RE: DROVE LANE, YAPTON

Reponses to Engineers Comments for Discharge of Planning Conditions
9 & 10

TYPICAL SUDS DETAILS  
SHEET 2 OF 2

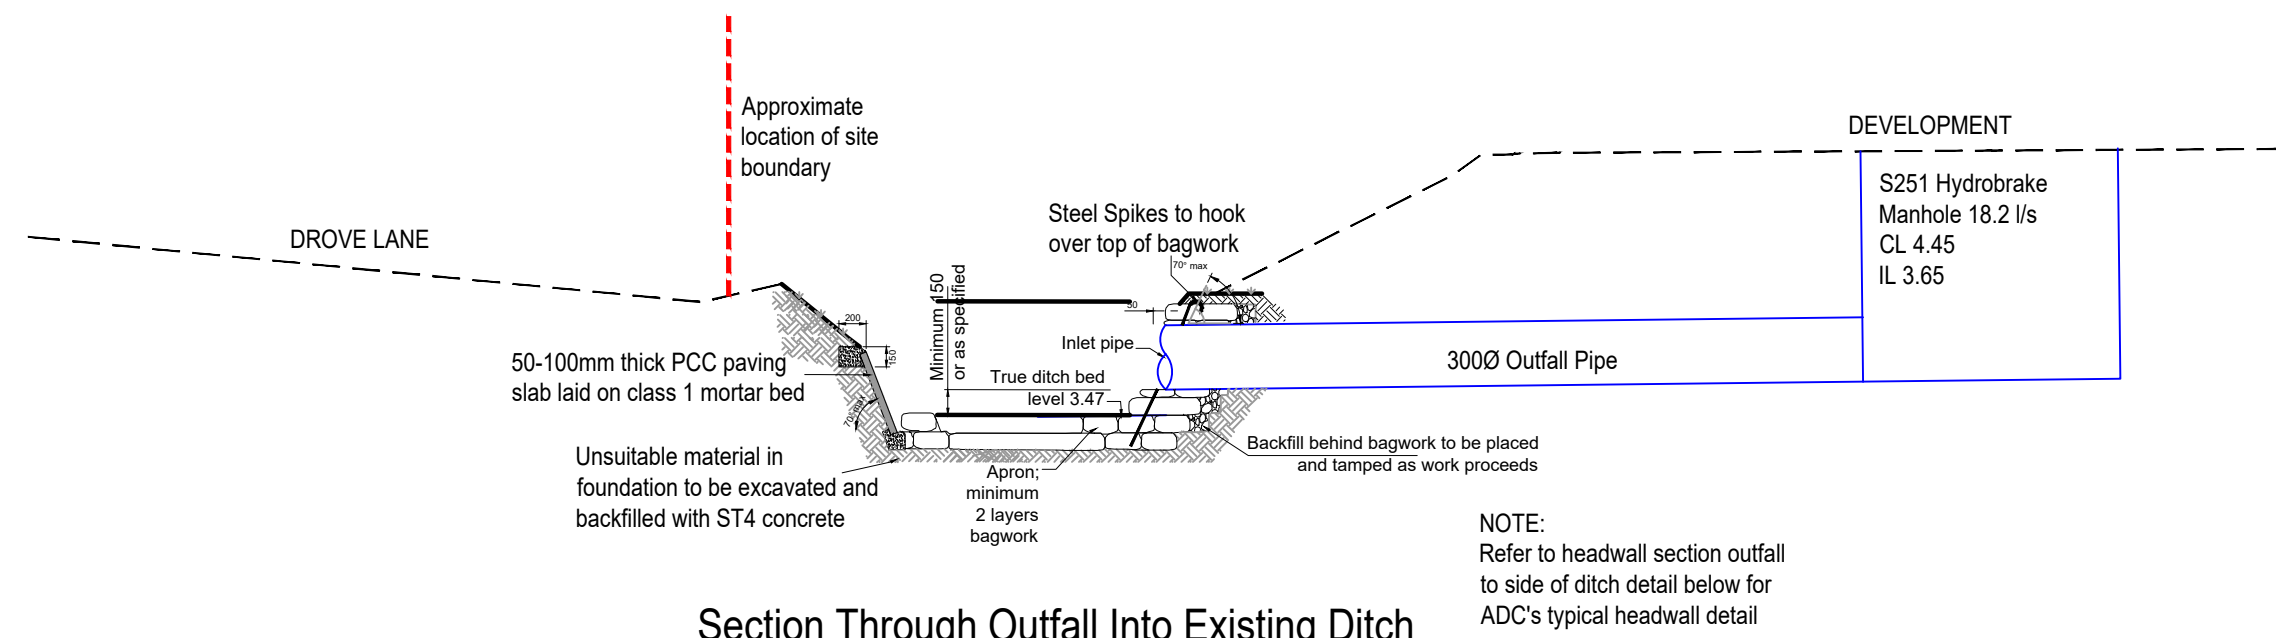
A site specific construction detail drawing of the outfall from the system to the watercourse should be provided. This should be consistent with the land drainage consent detail. _ _ Noted and section has been provided on Typical SuDS Details drawing 4103.

CLIENT BARRATT DAVID WILSON HOMES			DWG. TITLE TREE PIT DETAIL IN POS IN PROXIMITY TO LINED ATTENUATION FEATURE			
PURPOSE OF ISSUE PLANNING STAGE						
SITE YAPTON, DROVE LANE						
DRG BY AJW	CHECKED JBA	AUTH'D JBA	SCALE 1:20@A3	DATE FEB 2022	DWG NO. JBA 19/291 -DT4	REV. .

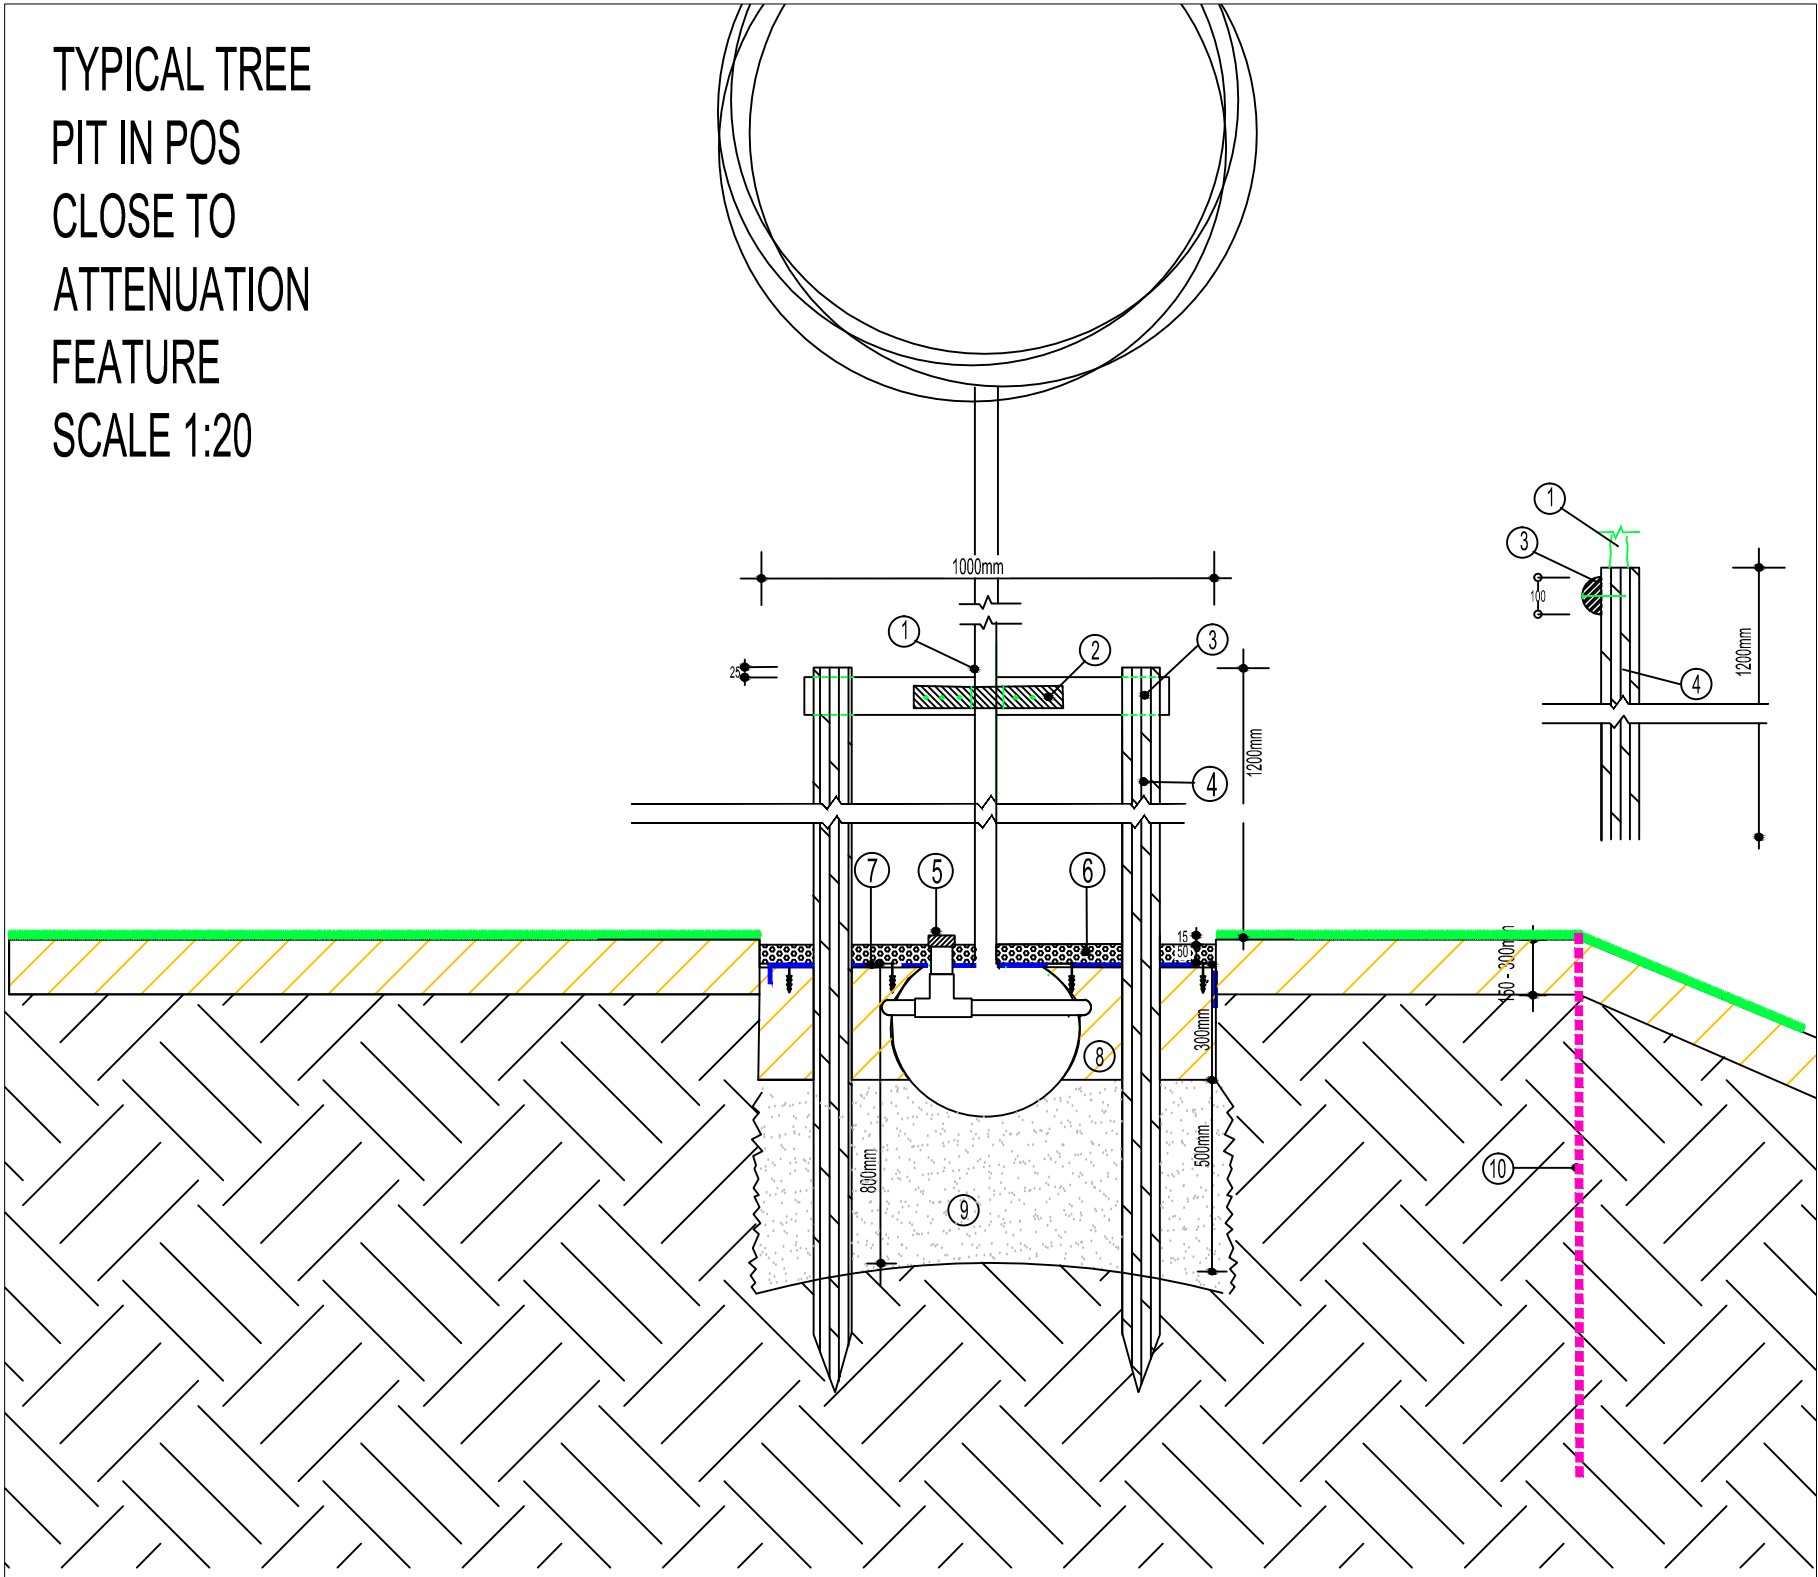
There is significant conflict between soft landscaping proposals and drainage proposals. A significant number of trees are proposed in very close proximity to lined surface water drainage features. Root potential areas should not overlap with SuDS features. We note that some root barriers are proposed, however we do not generally support these. Furthermore, the extent of the barriers proposed would not adequately protect the drainage features. _ _ Refer to Landscape Architects drawings.

Please can plans showing root potential areas of trees be provided, with drainage features shown. Once this is provided the tree officer should also be consulted. _ _ Refer to Landscape Architects drawings.
